Your Ref: OWPC23300
Our Ref: BR/73/19/PL 04-03-2019
Please ask for:
Mr S Davis

Erection of 3 No. terraced residential dwellings, garden/cycle storage sheds & associated parking utilising the existing access (resubmission following BR/214/18/PL). This application affects the setting of a listed building & affects the character & appearance of The Steyne, Bognor Regis Conservation Area.
Land To East Of Royal Norfolk Hotel Aldwick Road Bognor Regis

Thank you for your internet representation made on 31st May 2019 which has been recorded as '**an objection**' with the comments as follows:

Proposed layout showing the spacing around the terrace, gardens and parking and separation to the hotel to the west.

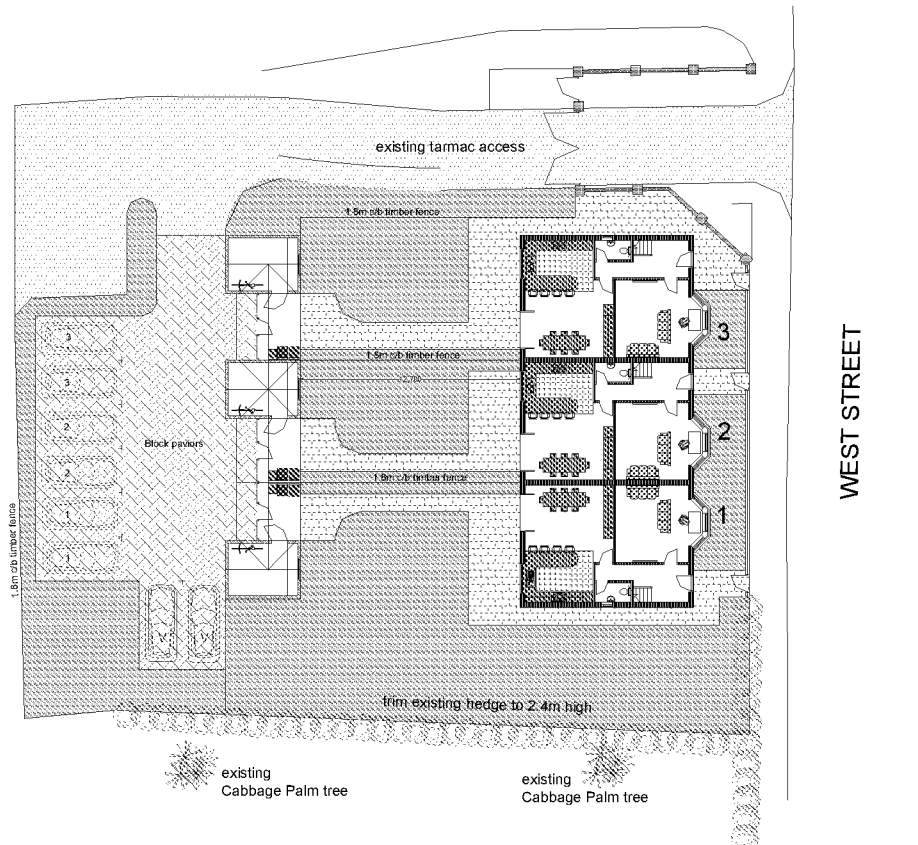
An access was duly agreed, and a drop kerb installed on the transferee's land to allow the access. The Mews was then designed around that access. The plan proposed for the new development ignores this and places a new entrance further west, adjacent to, and detrimental to, the visitor parking owned by RNMM Ltd..

The placing of the exit from the proposed new development adjacent to our established visitor parking constitutes a danger liable to cause an accident. This cannot be agreed and the existing entrance must be used and the plan amended.
